Bramford to Twinstead Reinforcement

Document 6.3.5.1: ES Appendix 5.1 – Scope of the Assessment

Final Issue A
April 2023

**FIGURE 6.3**

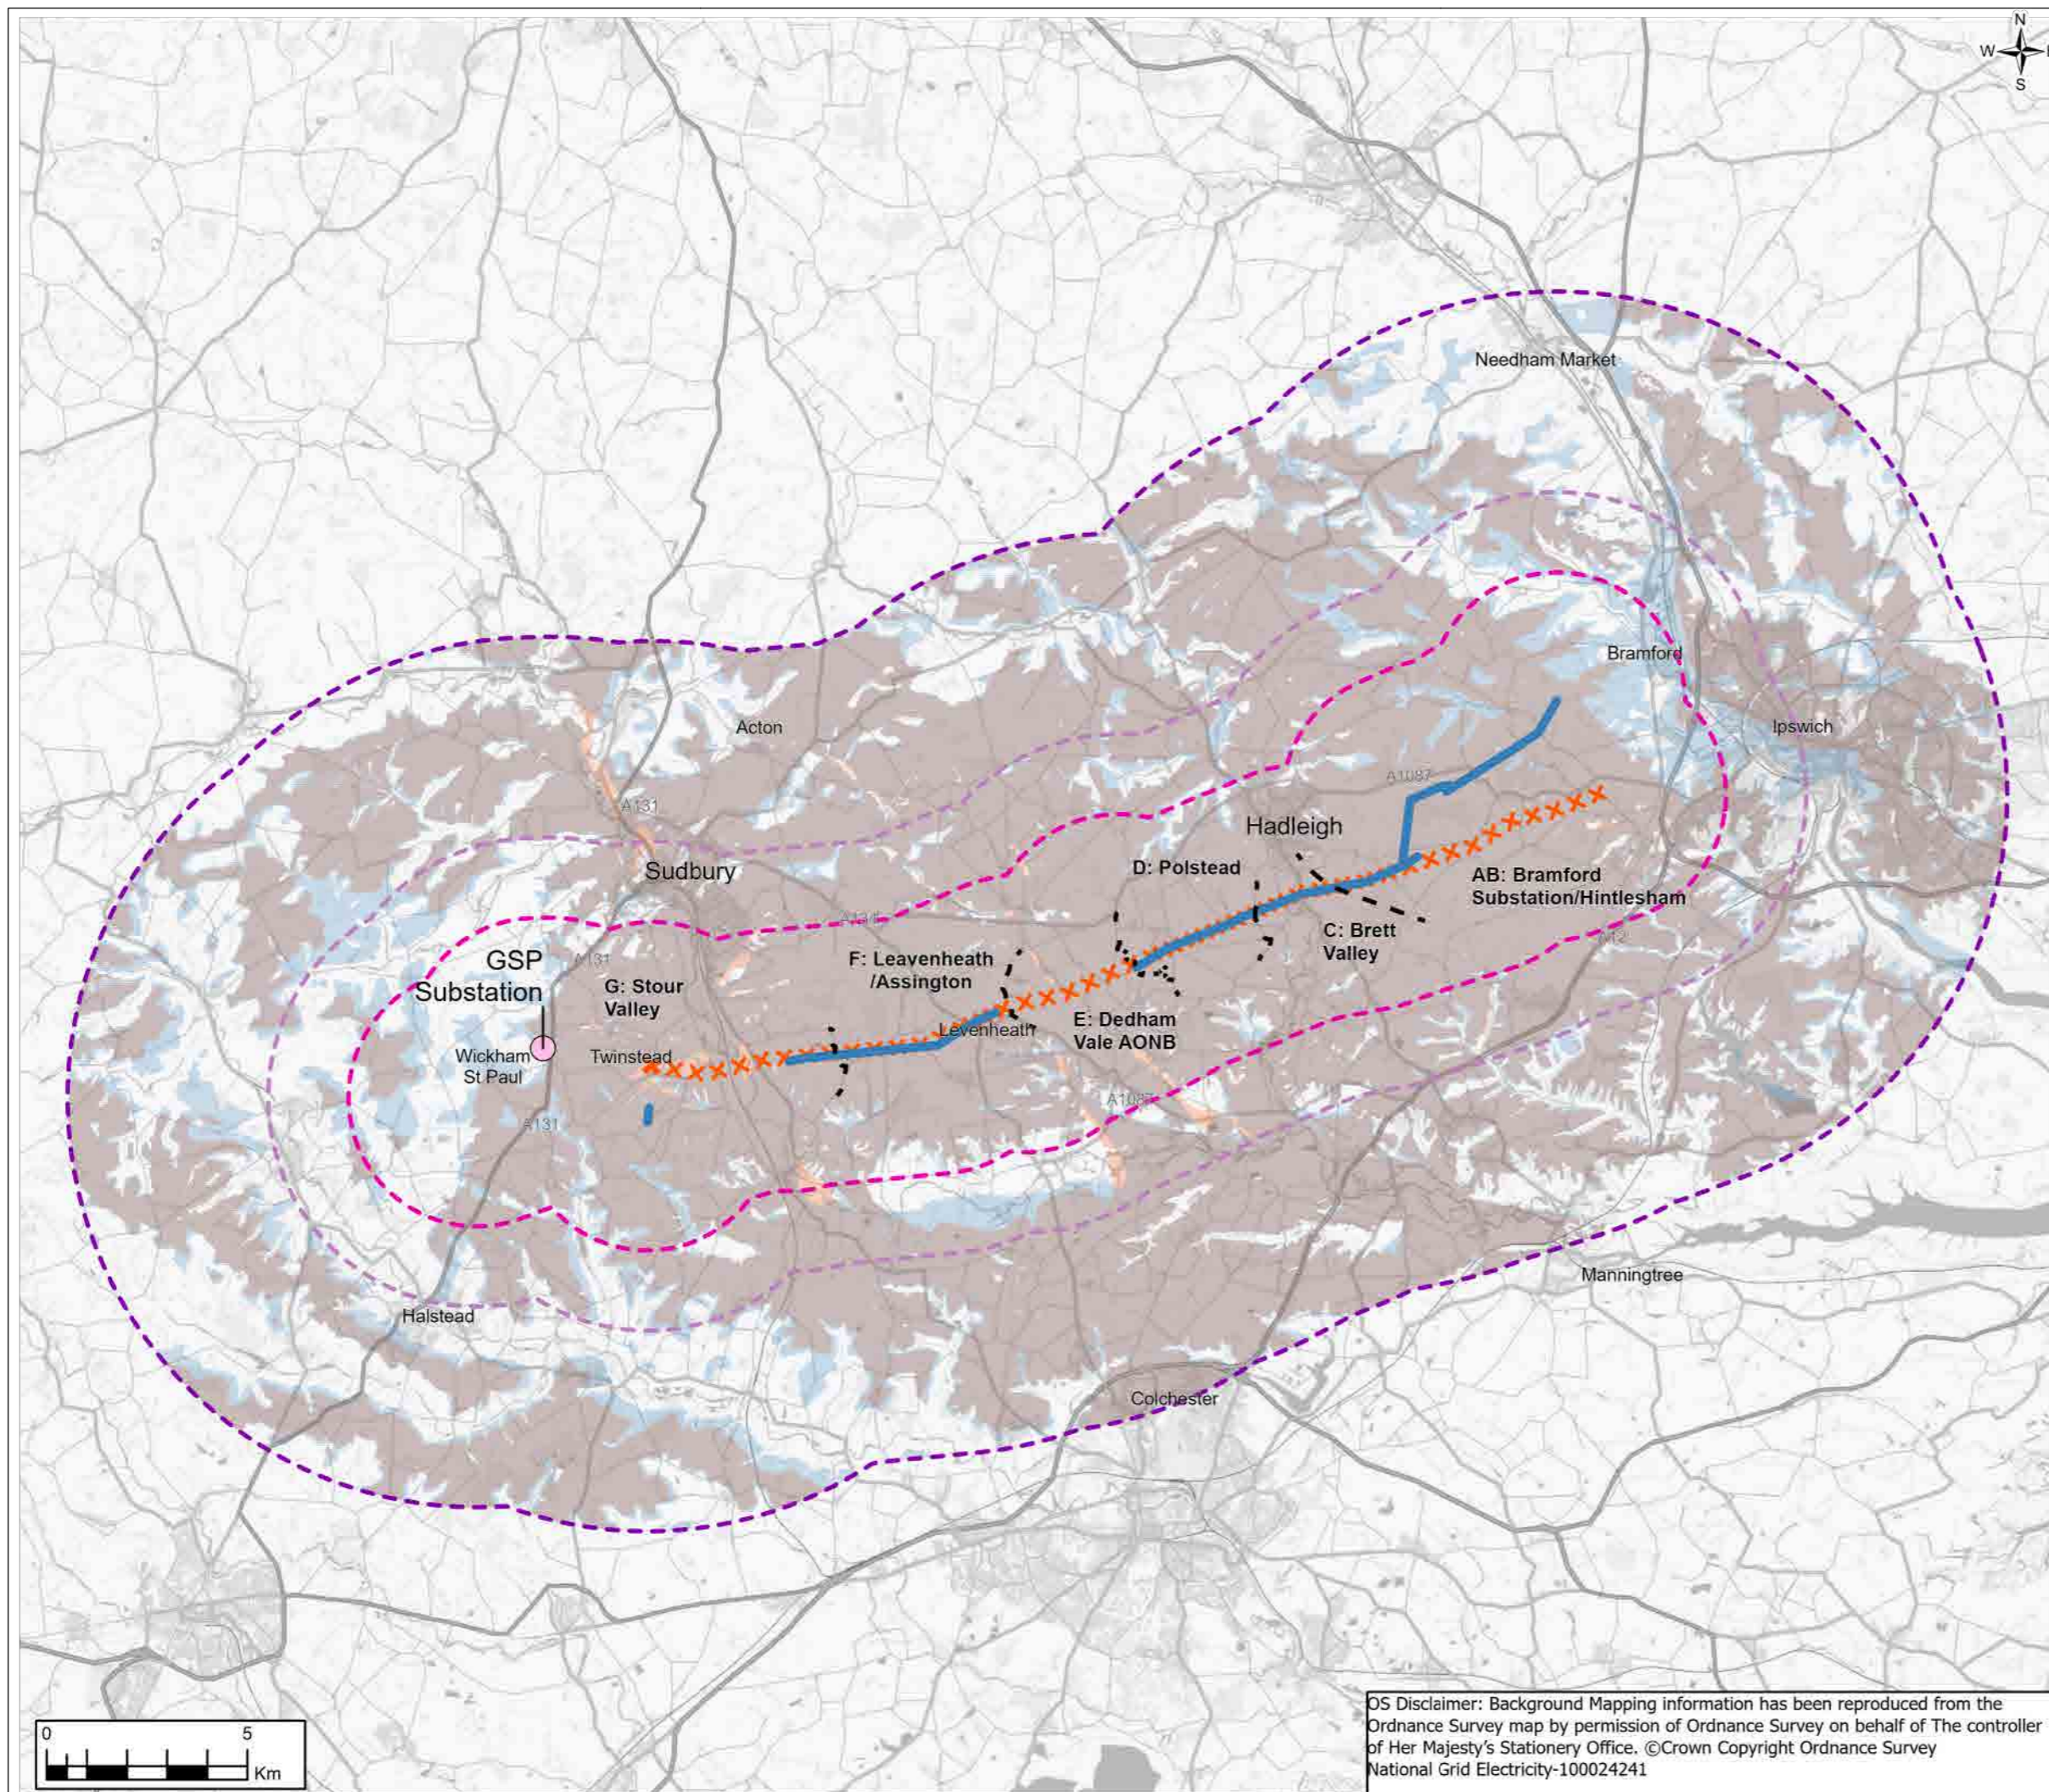
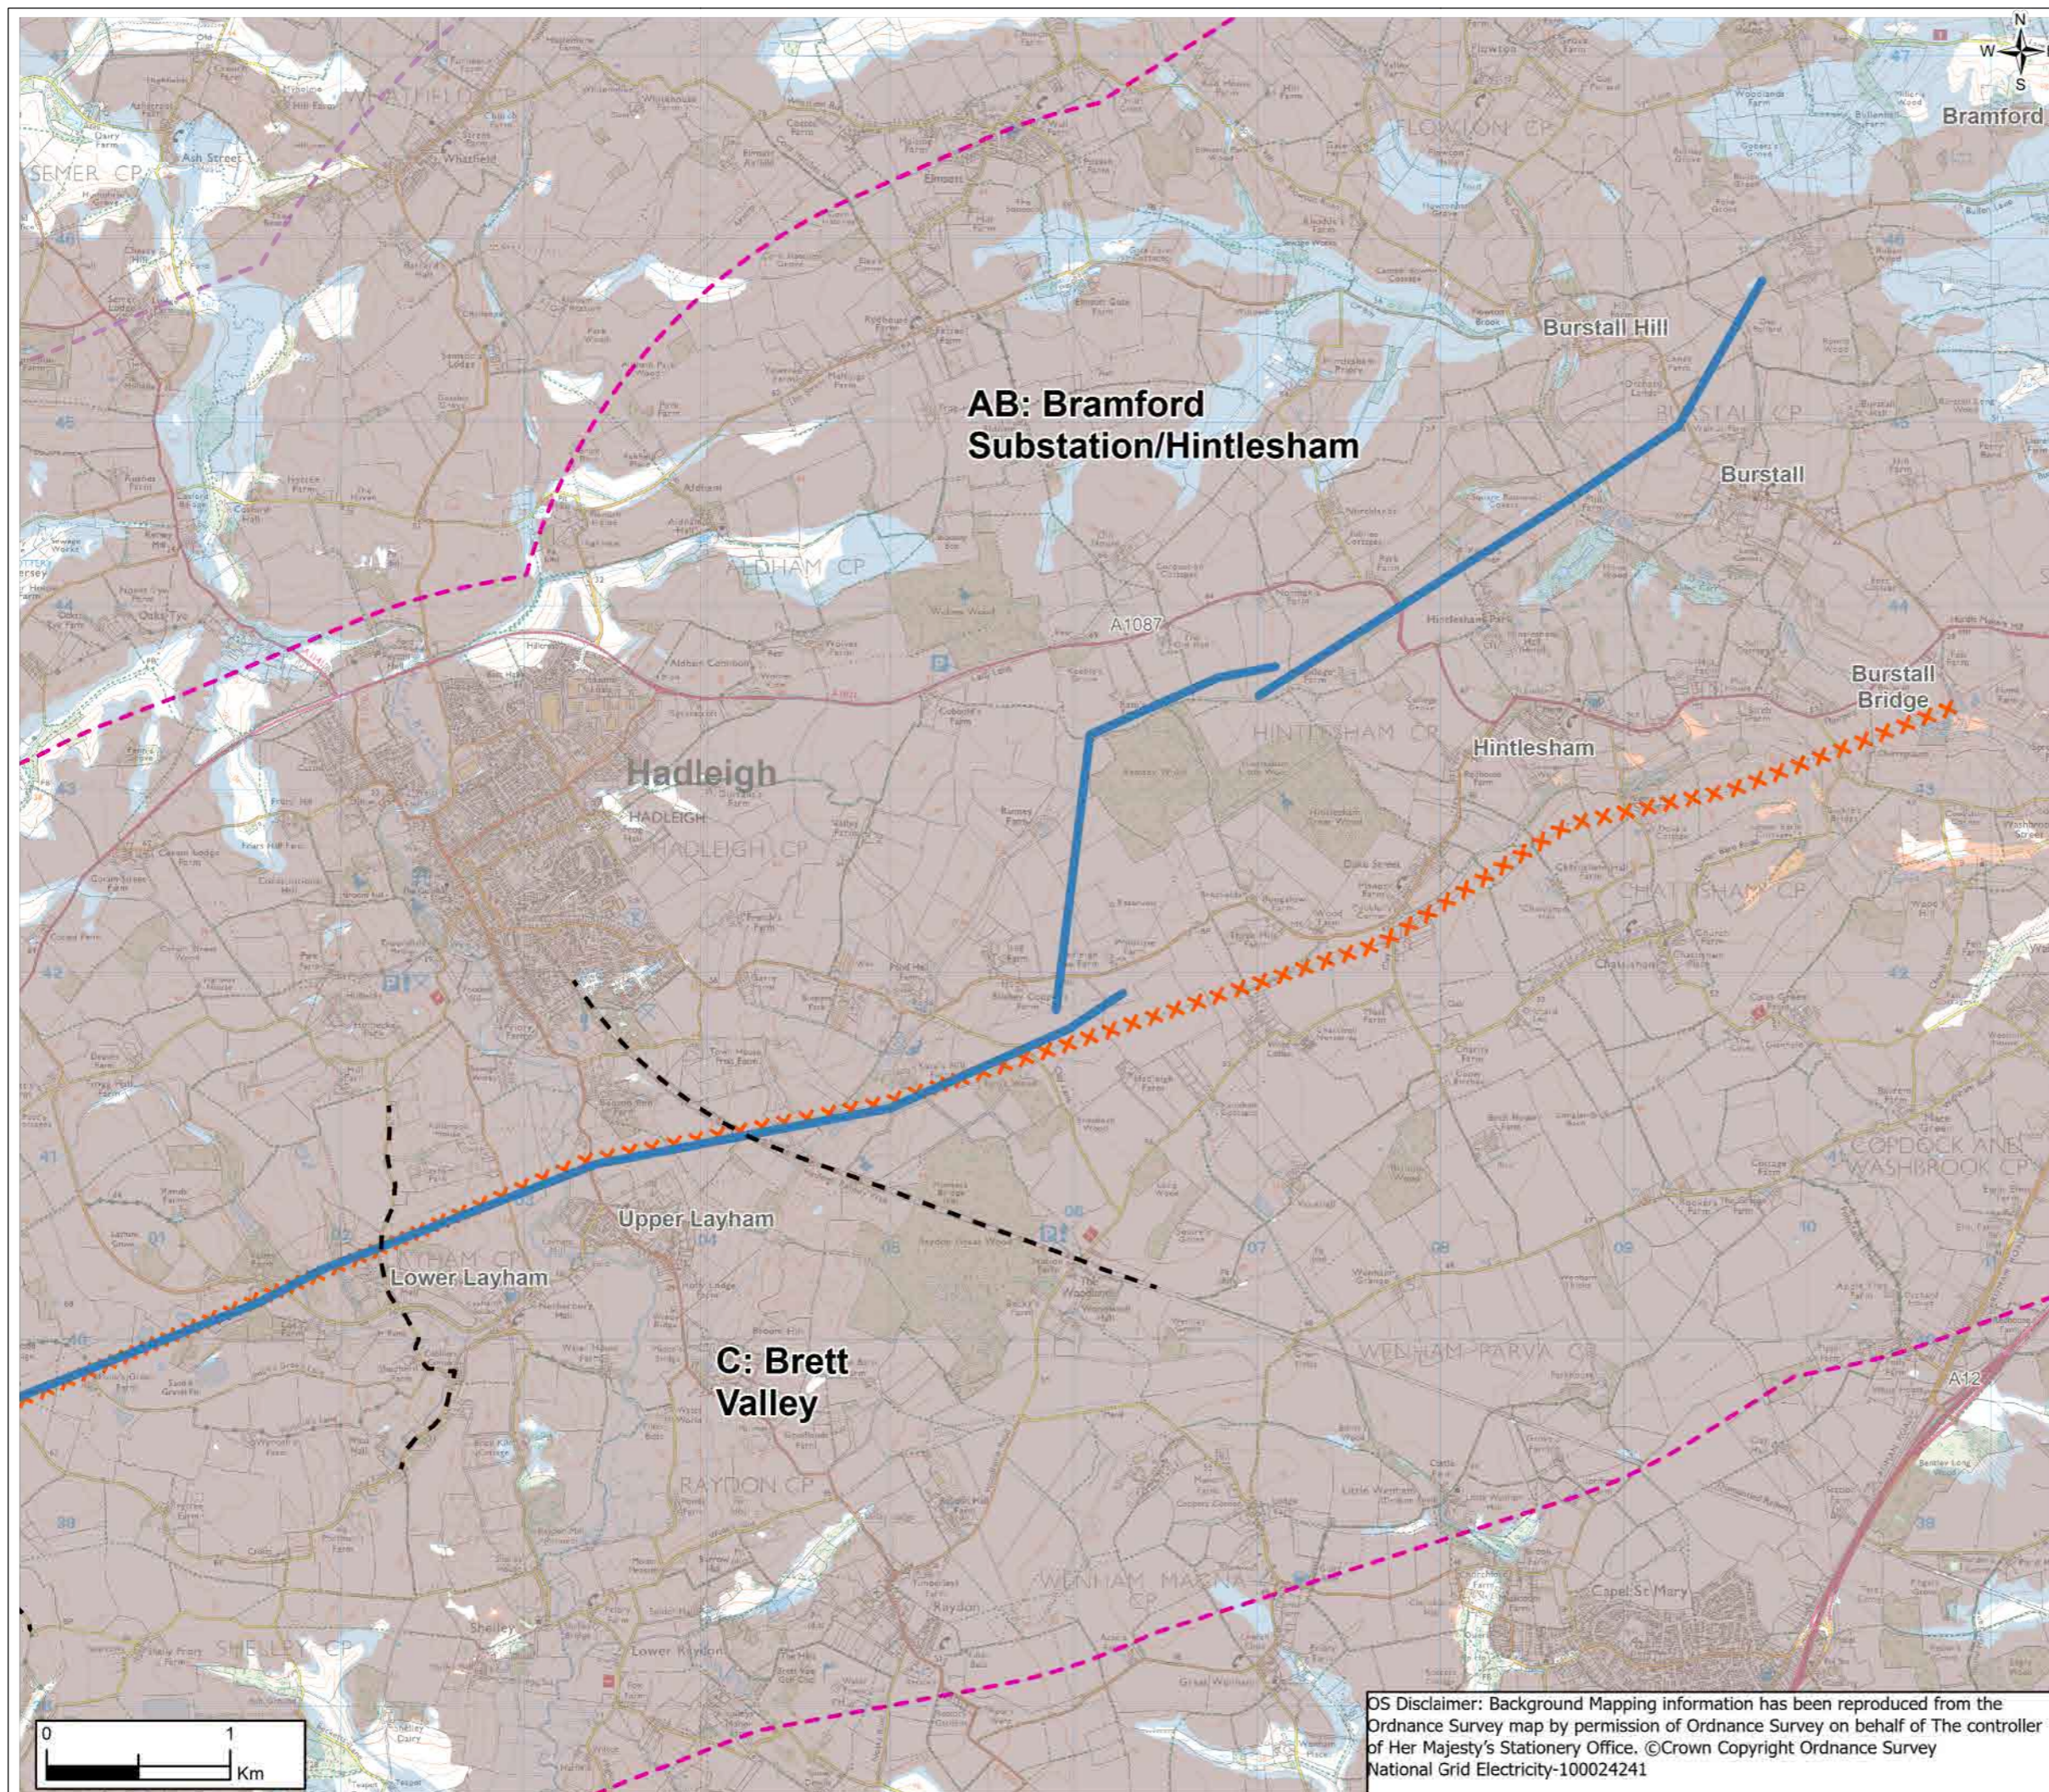
(ID 4.1.11) ZTV	The Scoping Report states that the draft ZTV excludes the area around the proposed GSP substation and CSE compounds. The final ZTV in the ES should ensure it encompasses all of the project.	The ZTV is presented on Figures 6.8 to 6.13 (application document 6.4). These include the final ZTV for all components of the project, including the CSE compounds and GSP substation.
